Surveyor's Affidavit of Correction

That I am a Licensed Professional Land Surveyor in the State of Colorado and a current Licensed Surveyor for Classic Consulting Engineers and Surveyors, LLC who prepared the Plat of FOREST LAKES FILING NO. 7, a subdivision of a tract of land situated in Section 29, Township 11 South, Range 67 West of the 6th Meridian, City of Monument, El Paso County, Colorado the said Plat of FOREST LAKES FILING NO. 7, having been recorded under Reception Number 222714981 of the El Paso County Records.

# FOREST LAKES FILING NO. 7

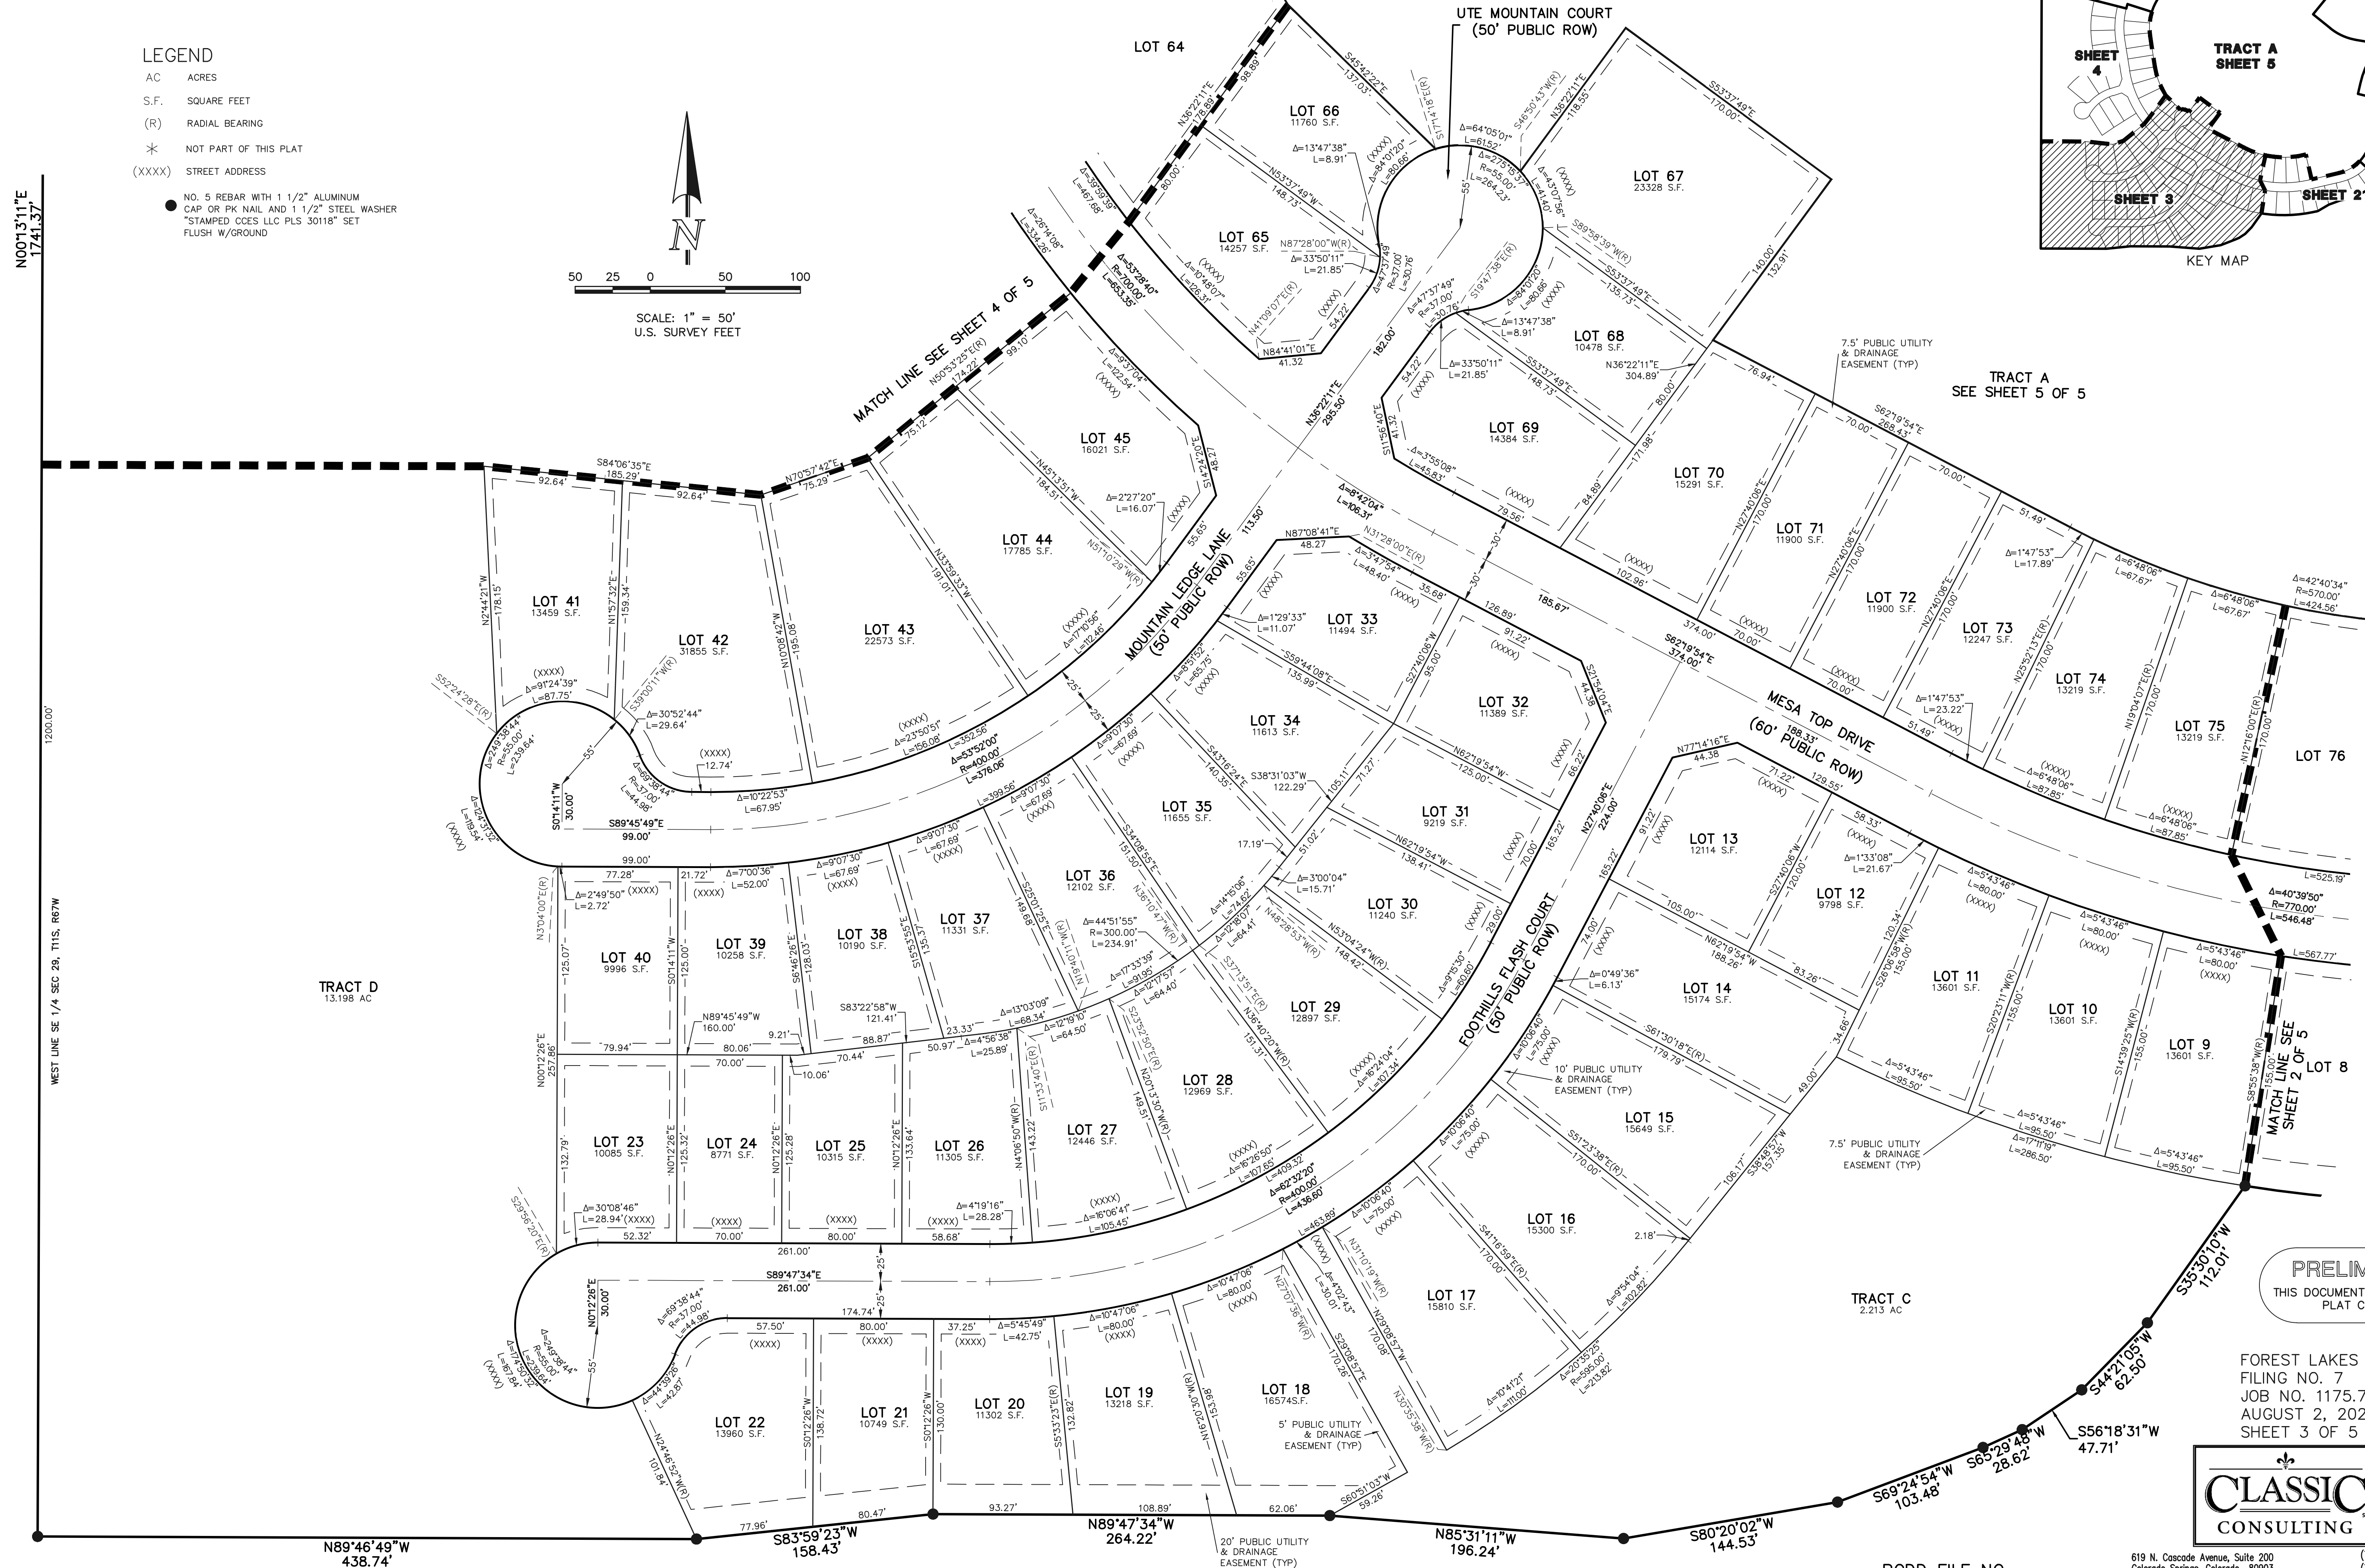
Affiant further states: the square footage for Lot 42, 4742 Mountain Ledge Lane is incorrectly shown on the face of said plat.

Said 31855 square feet is hereby correct to read as 21855 square feet on the face of the plat. This correction meets the requirements of CRS 38-51-111 (2) (b).
